Proposed Solar Farm and Bess Facility, Bardling's Drove, Sutton St. James, Spalding

Highways Technical Note

Response to Highways Comments from Lincolnshire County Council

21st February 2025

Project: FEN DYKE SOLAR FARM		
Client: INTEGRUM RENEWABLE ENERGY LTD		
Drawing: PROPOSED ACCESS ARRANGEMENTS - SITE 2		
Drawn By: MSF	Date: 25.06.2024	
Checked: SD	Scale: 1:1000	Paper: A3
Drawing No. AMA-22709-SK-003		Rev. P05

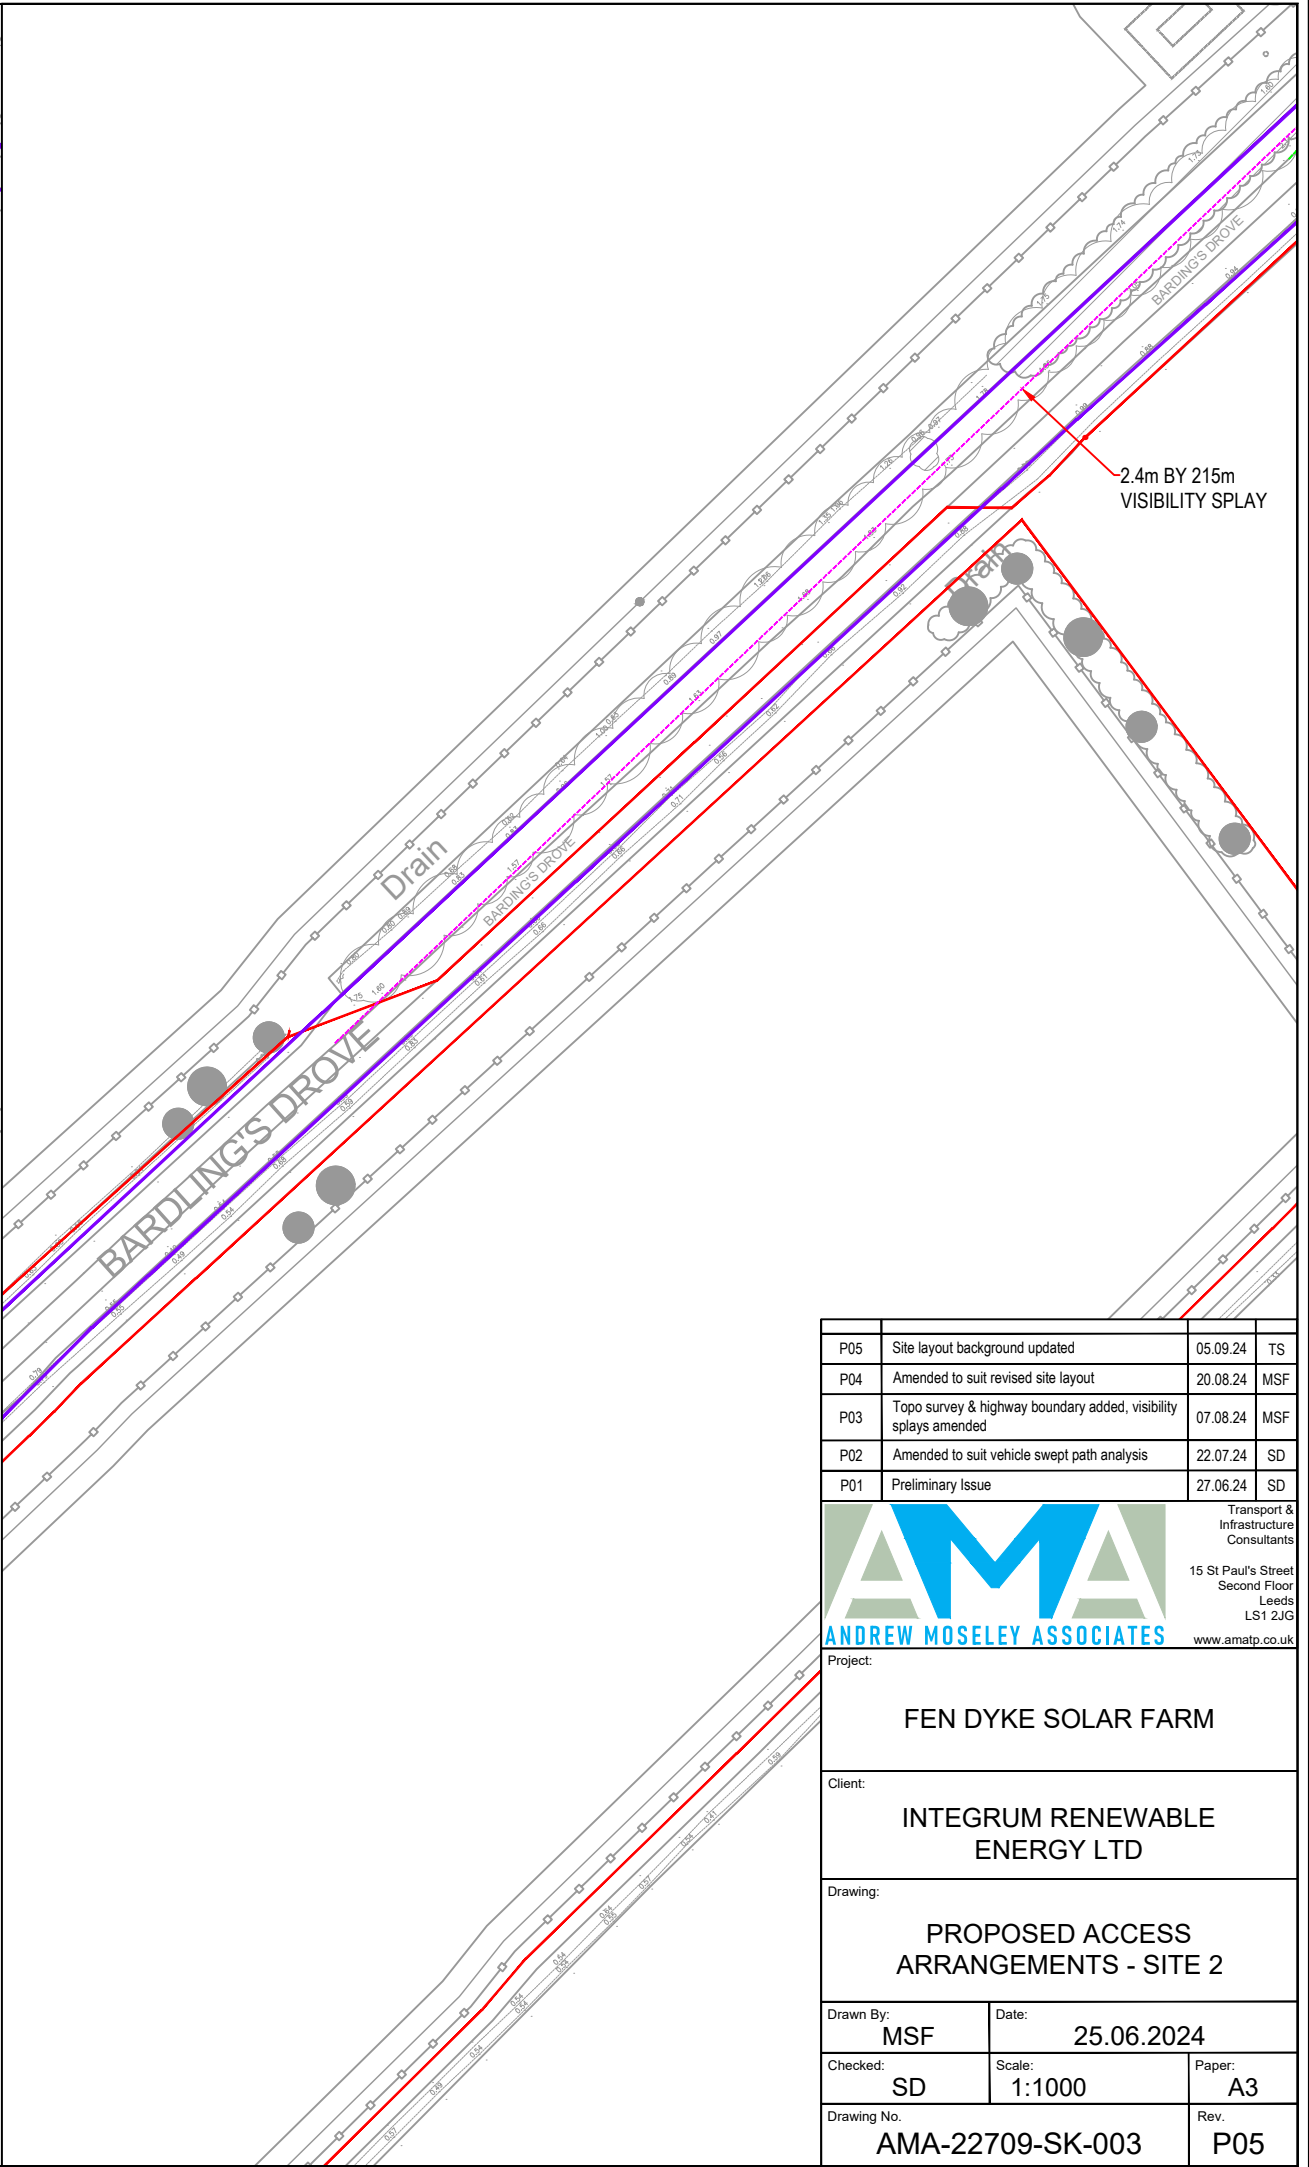
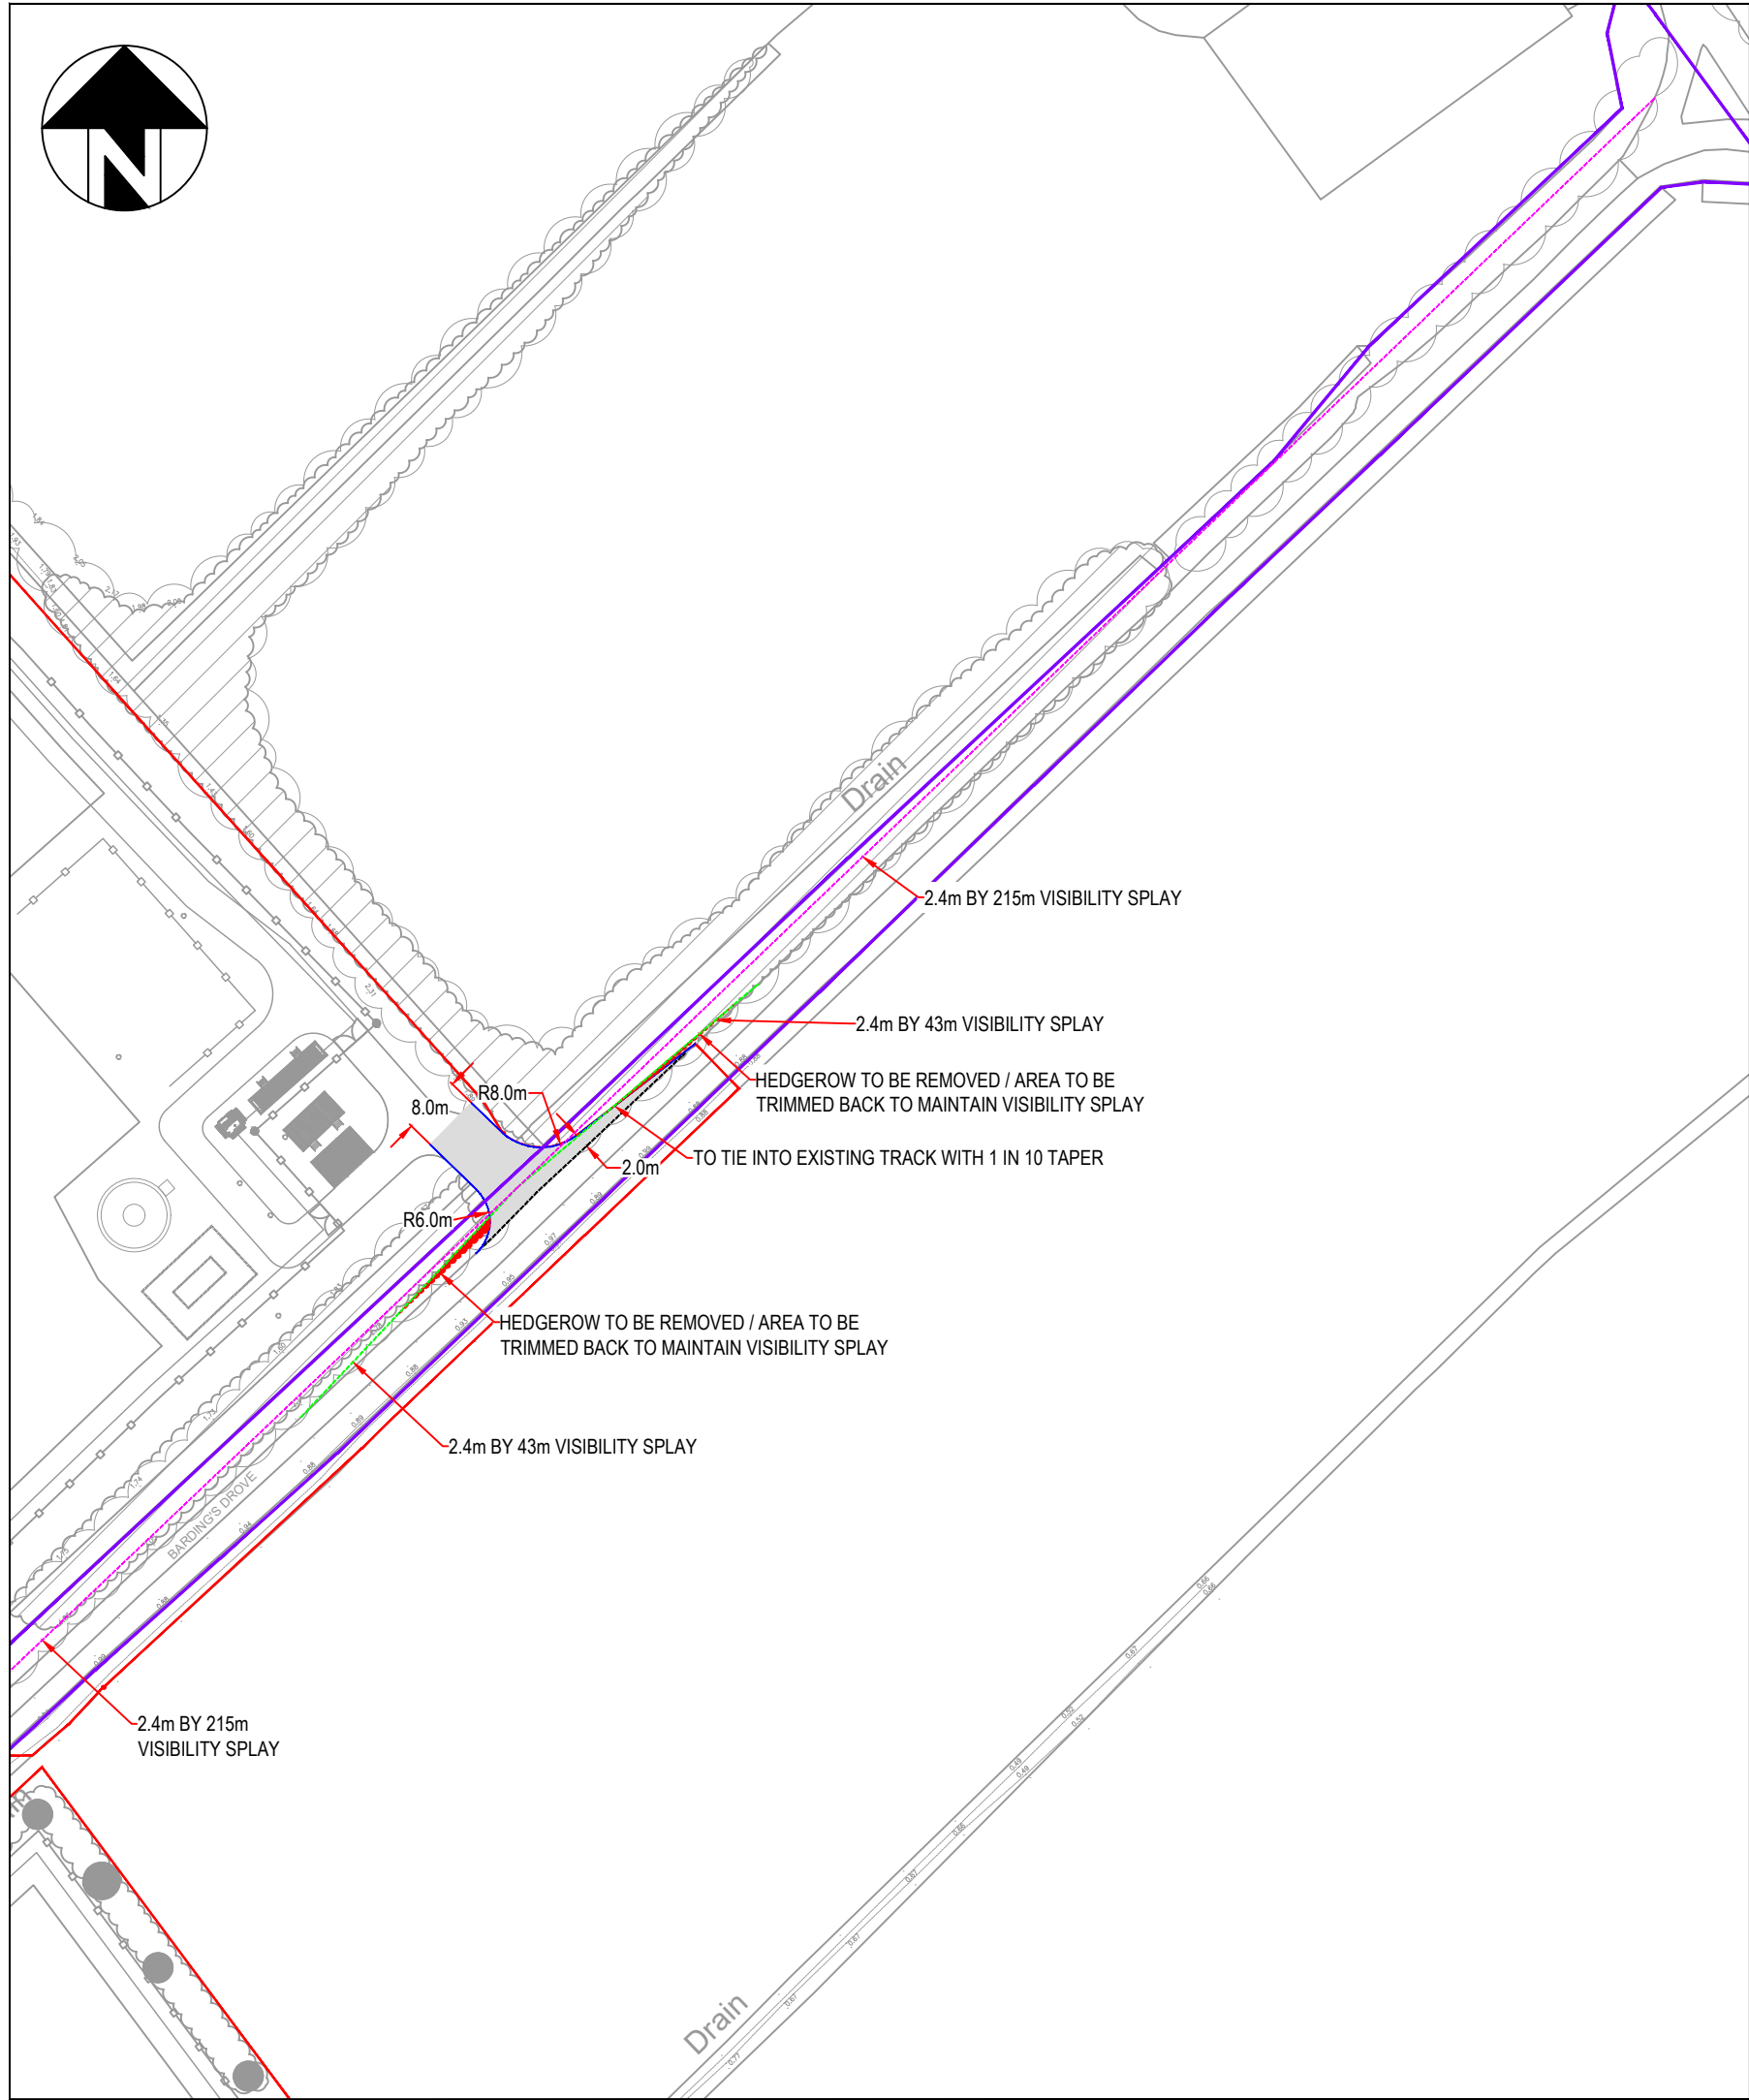
Visibility has been demonstrated in accordance with DMRB this is not necessary – they should be measured in accordance with Manual for Streets.

Detailed access drawings are required with swept path drawings detailing the largest size vehicle that will be accessing the sites.

Whilst this response is open ended, AMA have taken into account LCC's views regarding the rural and lightly trafficked nature of these roads and therefore consider the provision of visibility splays in line with Manual for Streets (MfS) for a 30mph road appropriate. All visibility splays have been updated as requested and these can be viewed at [Appendix C](#).

AMA can confirm all construction accesses will be constructed in accordance with LCC specification, and AMA's preliminary drawings have been updated to reflect this. Please see [Appendix C](#).
